Recommendation Report for Planning Permission for Works or Extension to a Dwelling

REF NO: AW/214/20/HH

LOCATION: 15 Fernhurst Gardens
Aldwick
PO21 4BA

PROPOSAL: Proposed side extension and dormer enlargement.

Proposed Ground Floor Plan

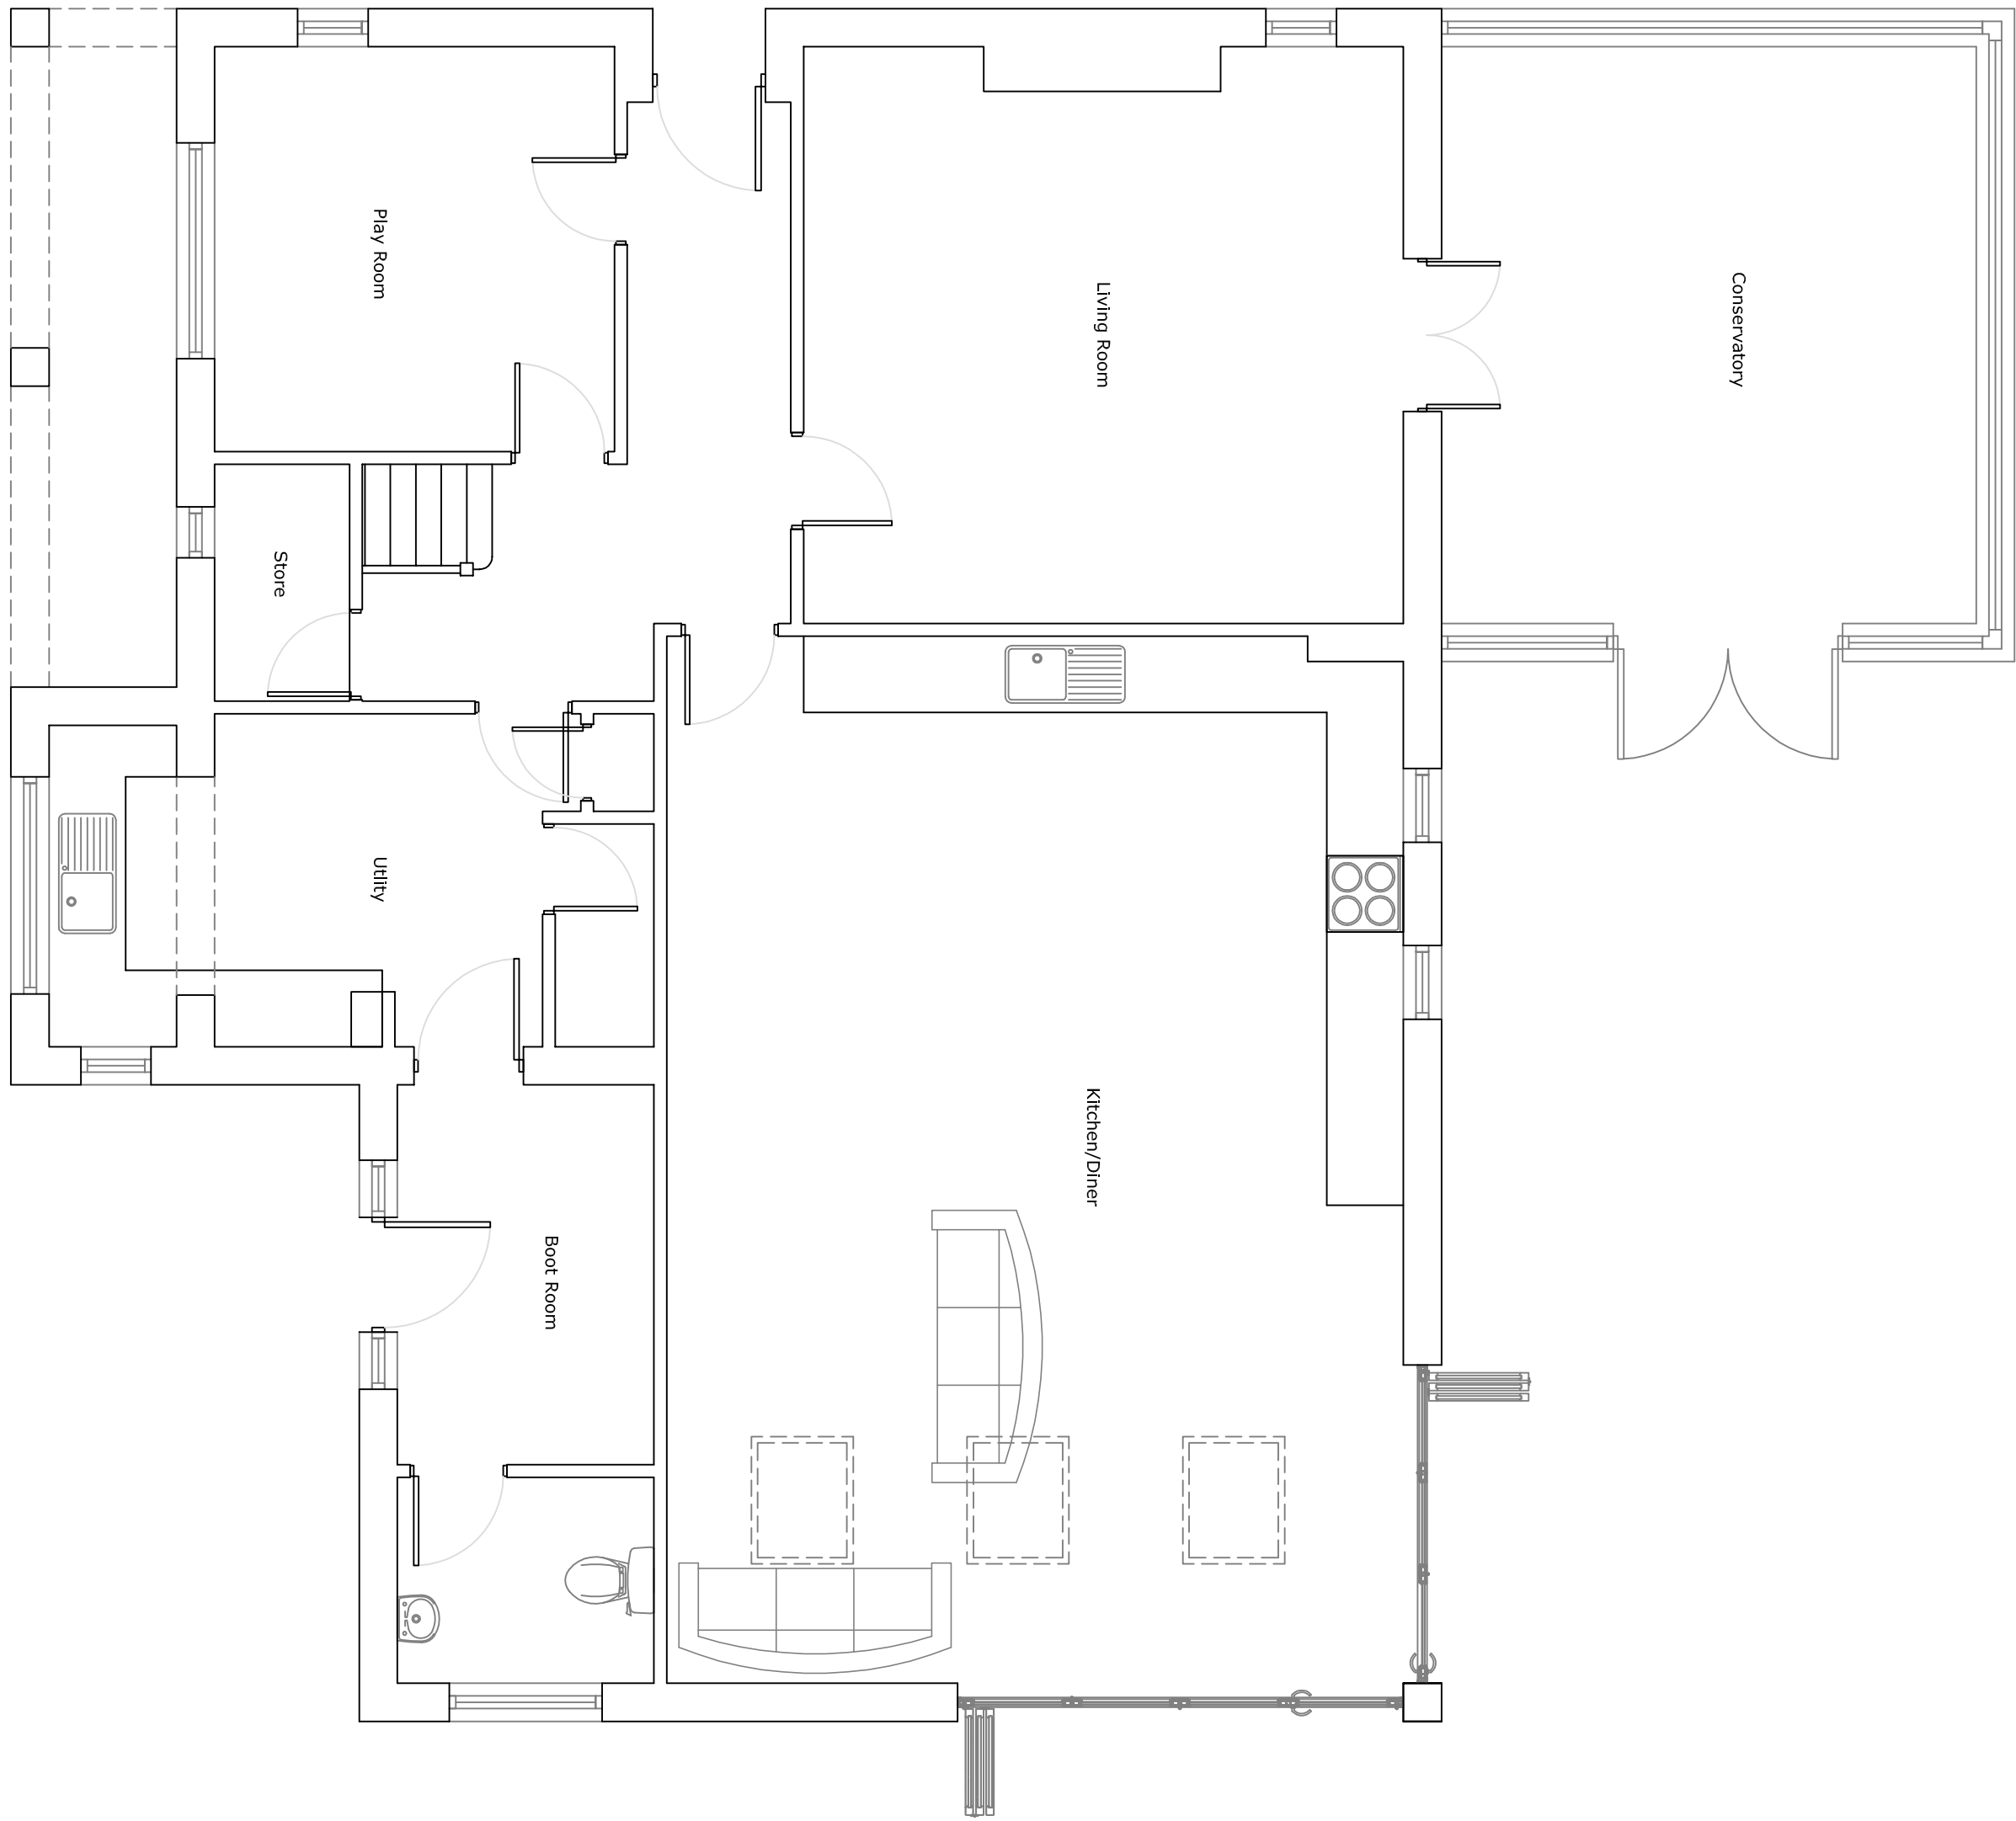
An existing conservatory to the southern elevation will be removed and replaced with a larger extension. This will run along the side of property at a depth of 8.4m and have a width of 5m. There will also be a conservatory constructed to the eastern rear elevation with a depth of 4.5m and a width of 5m. The extensions will have eaves to a height of 2.7m with a flat hipped roof to a height of 3.45m.

The rear addition extends only slightly beyond the neighbouring property and with no windows to the side of the neighbouring property or to the north of the conservatory and with around 3.5m retained to the boundary, it is not considered to result in adverse overbearing or overshadowing impacts.

There will be a number of windows to the southern and eastern sides of the extensions however due to the separation distance and with the development at single storey, it is not considered to give rise to adverse overlooking.

Proposed South Elevation

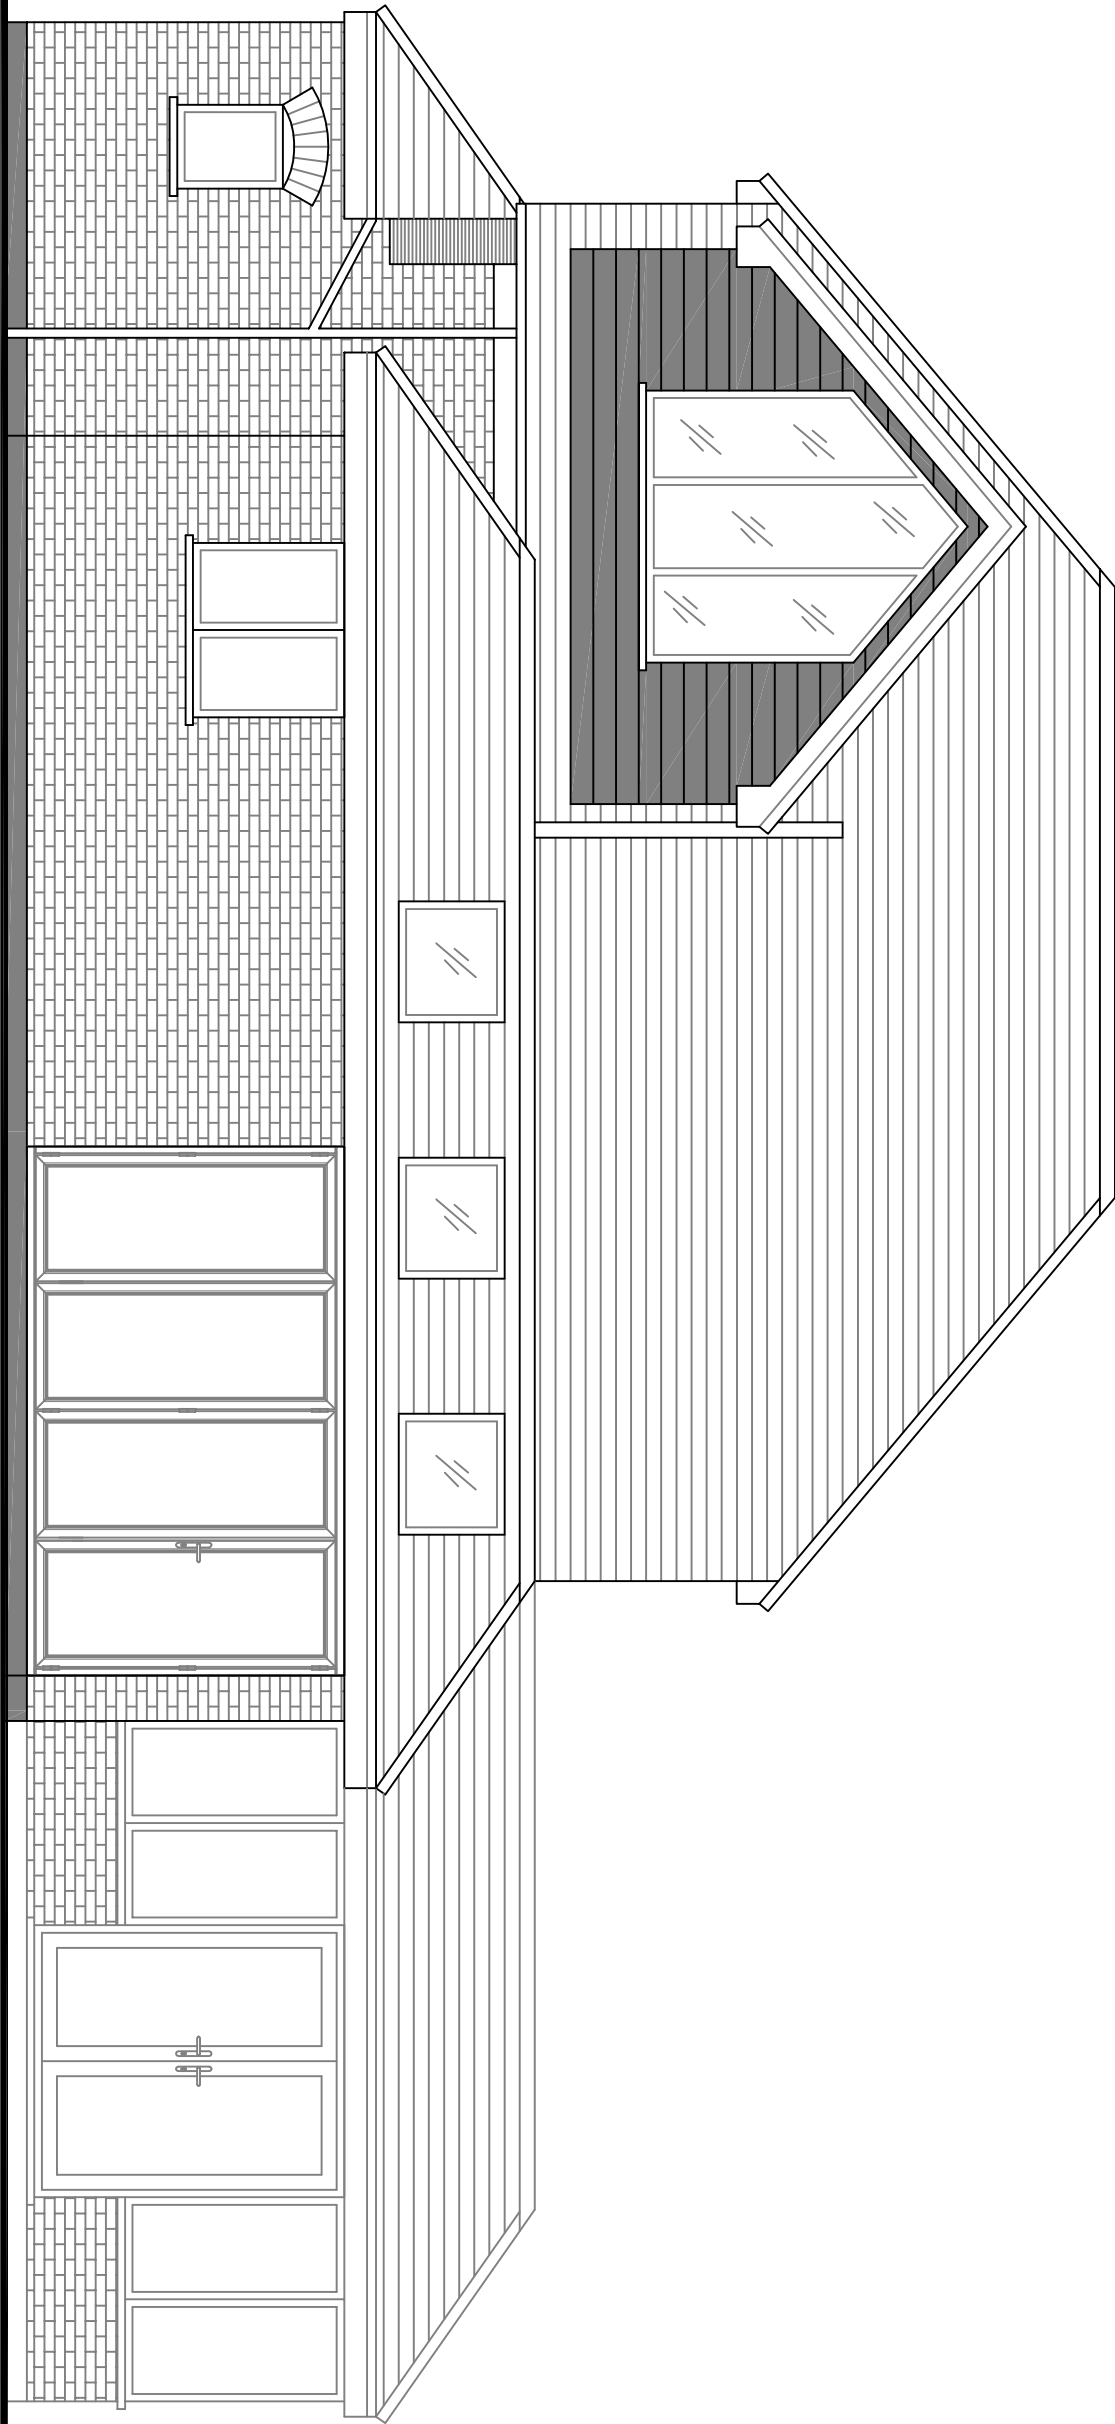
There is also an existing dormer to the southern elevation which will be made larger. This will have a depth of 3.6m and a height of 3m with a gable roof. It will also have a large window. Whilst there is some separation and boundary screening, it will be conditioned that the window should remain obscured glazed to ensure it does not give rise to adverse overlooking upon the property at 'The Quest'.

- 3 The dormer window to the southern elevation of the building shall at all times be glazed with obscured glass and only openable at a high level, at least 1.7m above finished floor level.
